Horsham District Council Deadline 6 Submission

## **EN010117: Application by Rampion Extension Limited for the Rampion 2 Offshore Wind Farm**

HDC Response to the Applicant's additional information/submissions received Deadline 5.

System Identifier: 42285-WSPE-EX-ON-FG-OL-7754
Version: 2

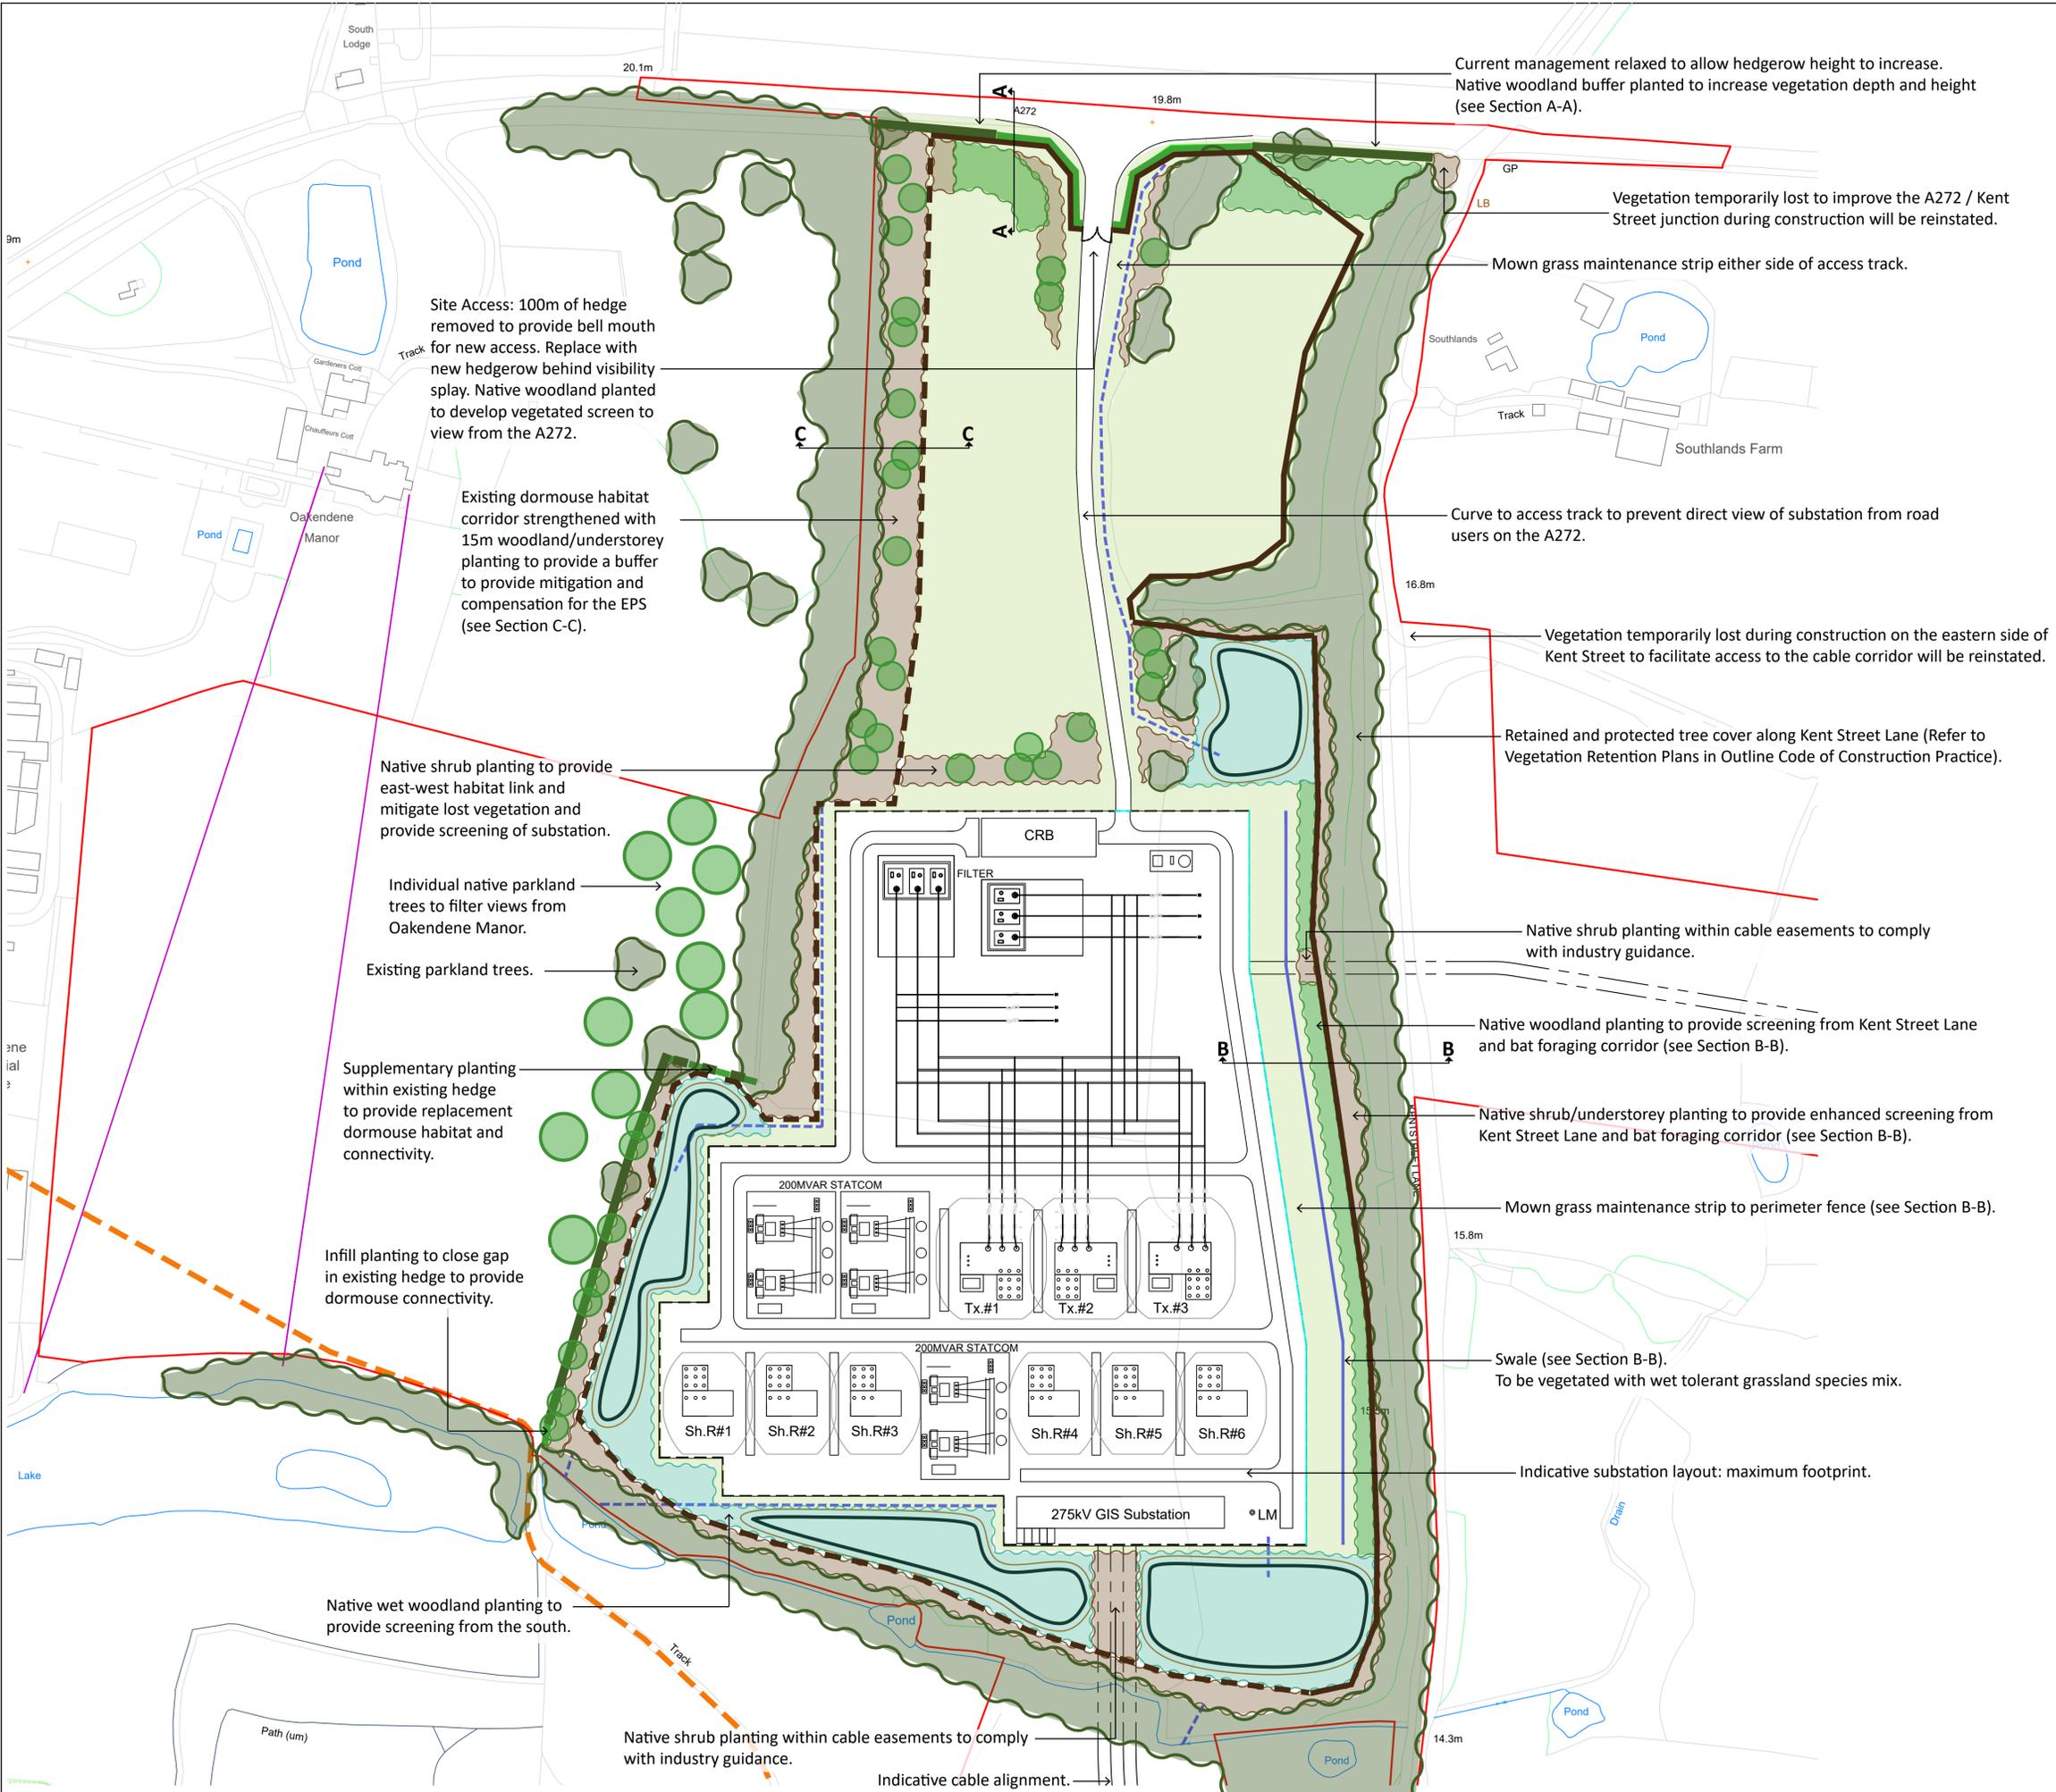
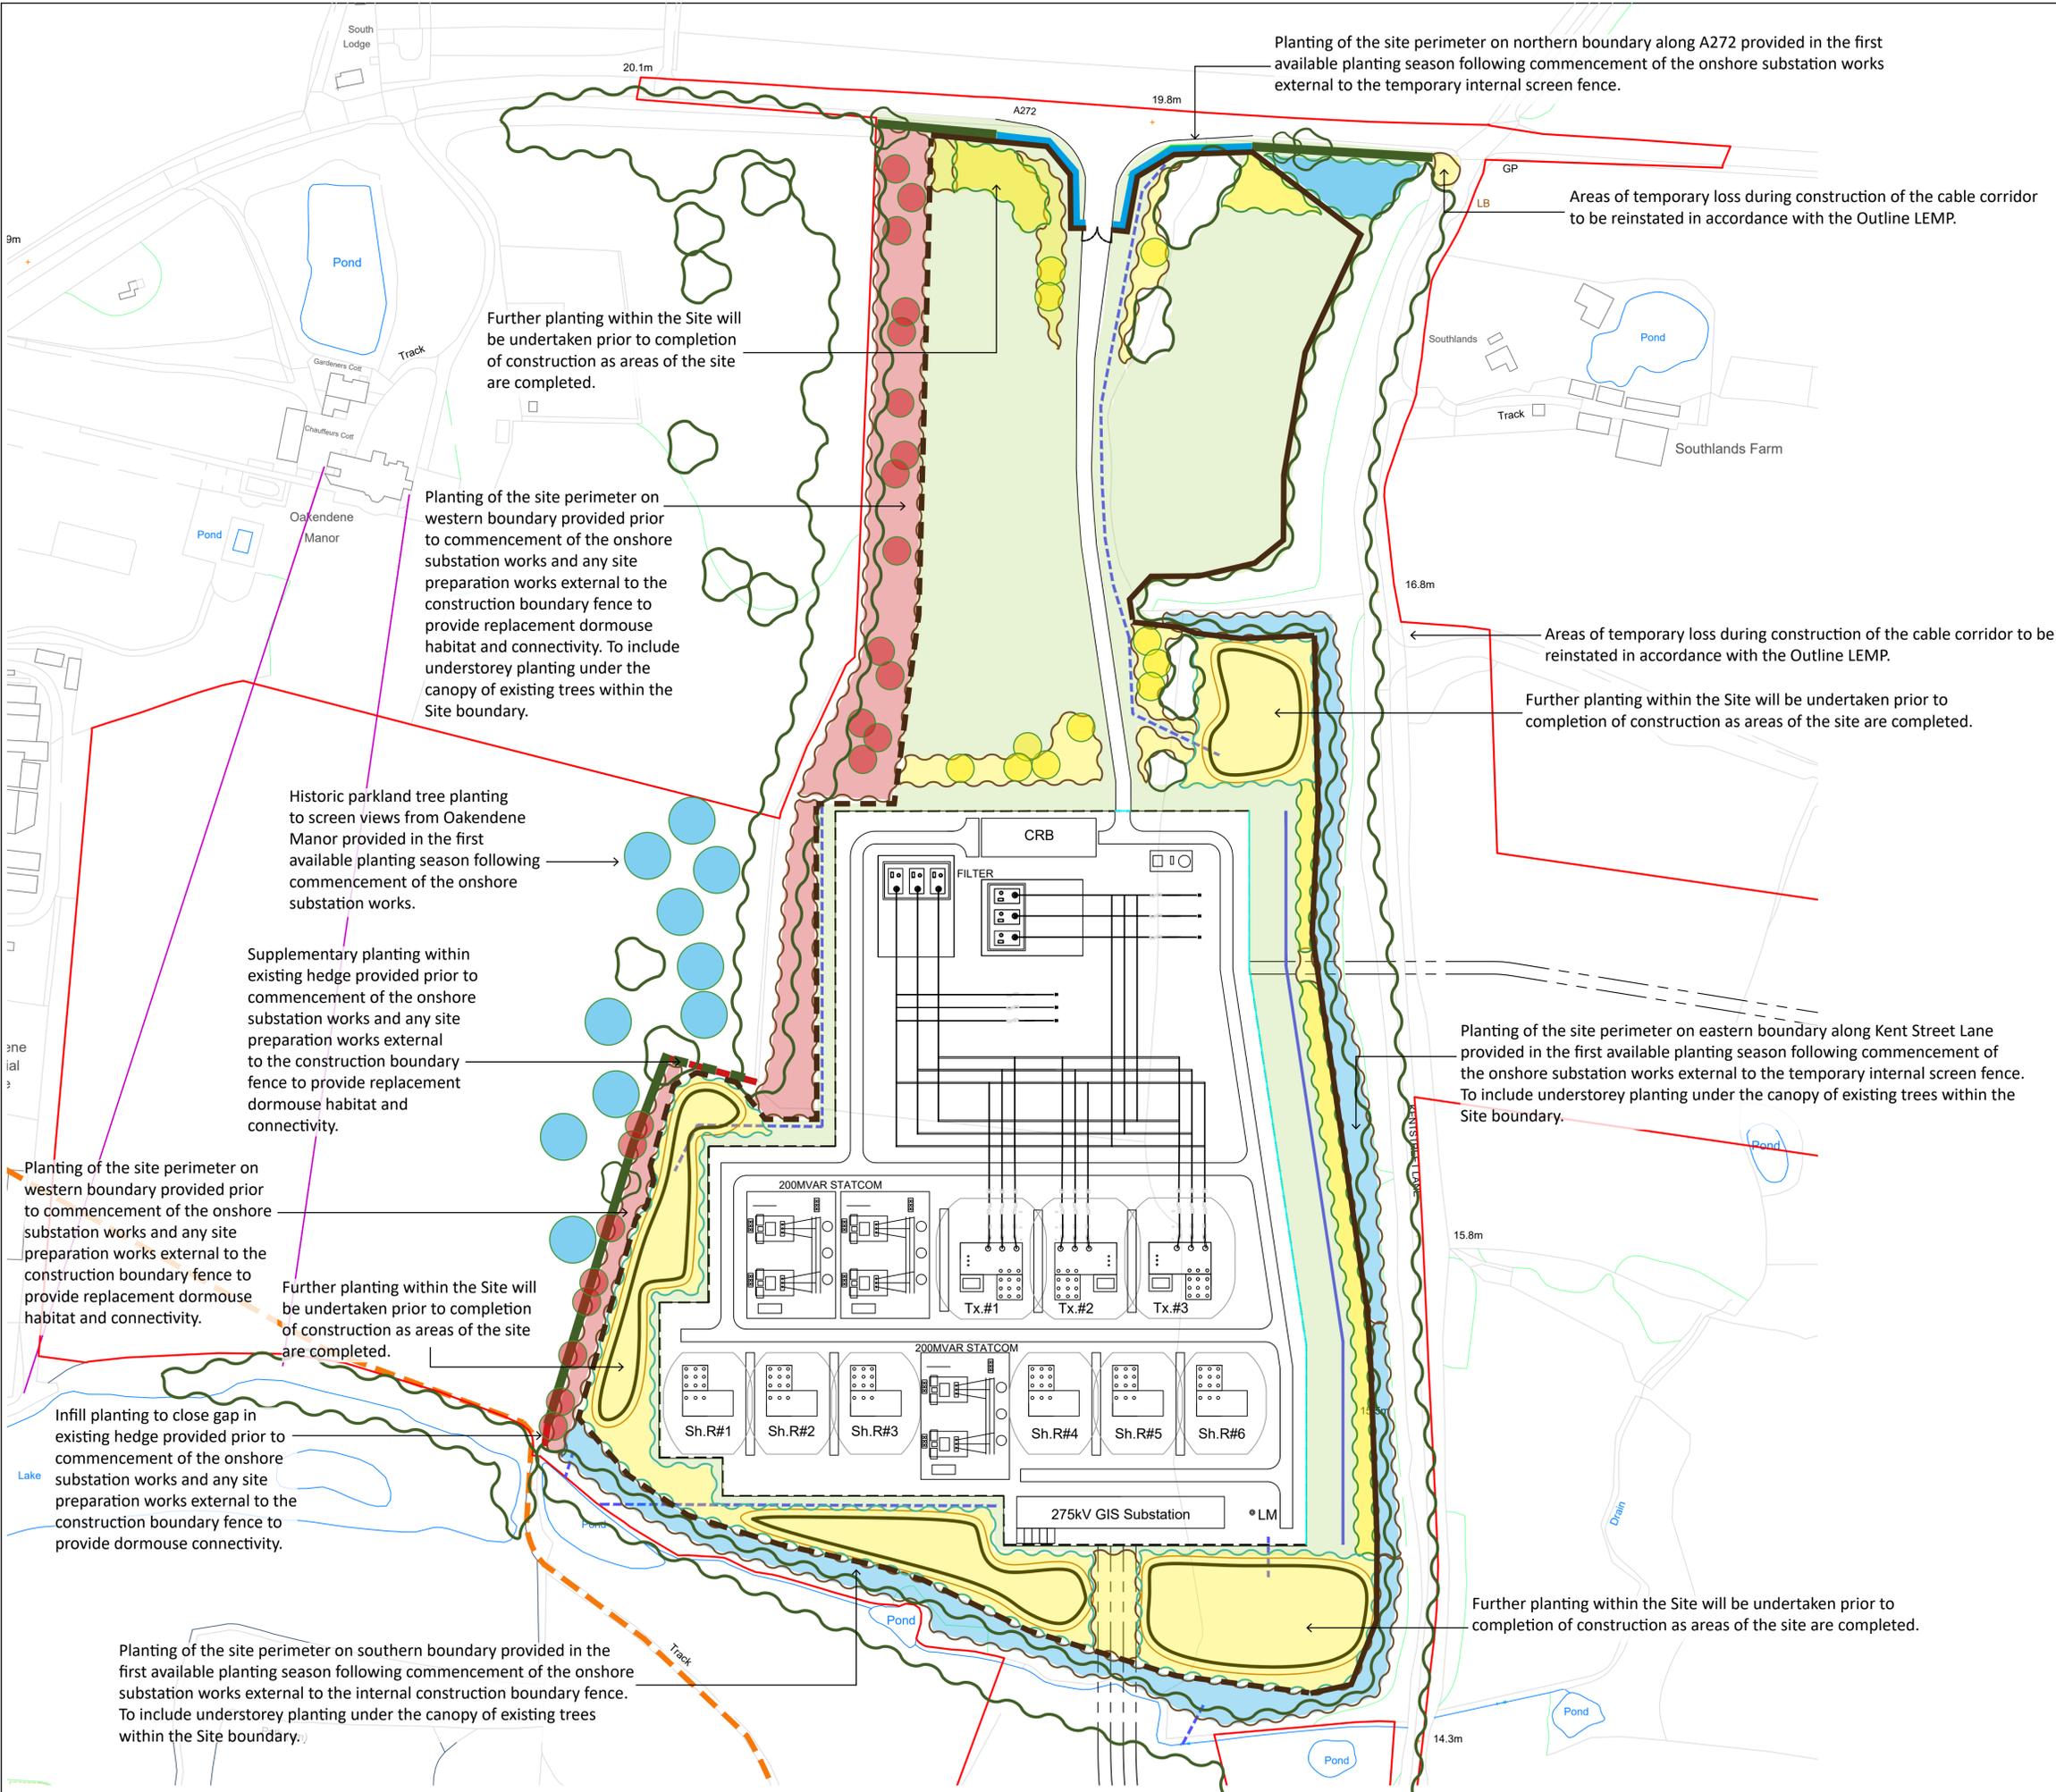
traffic should not be routed through Storrington. C-158 should be altered to include Storrington and Cowfold and the OCTMP revised accordingly.
<b>[REP5-073] Outline Landscape and Ecology Management Plan (tracked) REV D</b>	<p>It is advised against the inclusion of Box species within Mix E (as listed in Appendix 22.16 Arboricultural Impact Assessment, APP-194) for hedgerows, given the increasing prevalence of non-native Box Tree Moth and its decimation of box hedges in recent years. This degree of devastation could have impacts on landscape and ecology mitigation. It is also argued that when mitigating for habitat qualities, native species mixes should be prioritised. Therefore, species listed within Mix B will suffice for hedgerow planting. It is understood that species planting compositions will be addressed within stage specific plans.</p> <p>Please note HDC's requirement at Deadline 5 [REP5-150] to amend wording to the Indicative planting phasing plan 42285-WSPE-EX-ON-FG-OL-3902 appended to this document. Recommended wording as follows:  'First available planting season prior to the erection of perimeter fencing'. It is also recommended that the key includes the following wording: Temporary close board fence to have access points suitable for maintenance of the landscaped areas.</p> <p>Otherwise acknowledge changes and no further comments.</p>
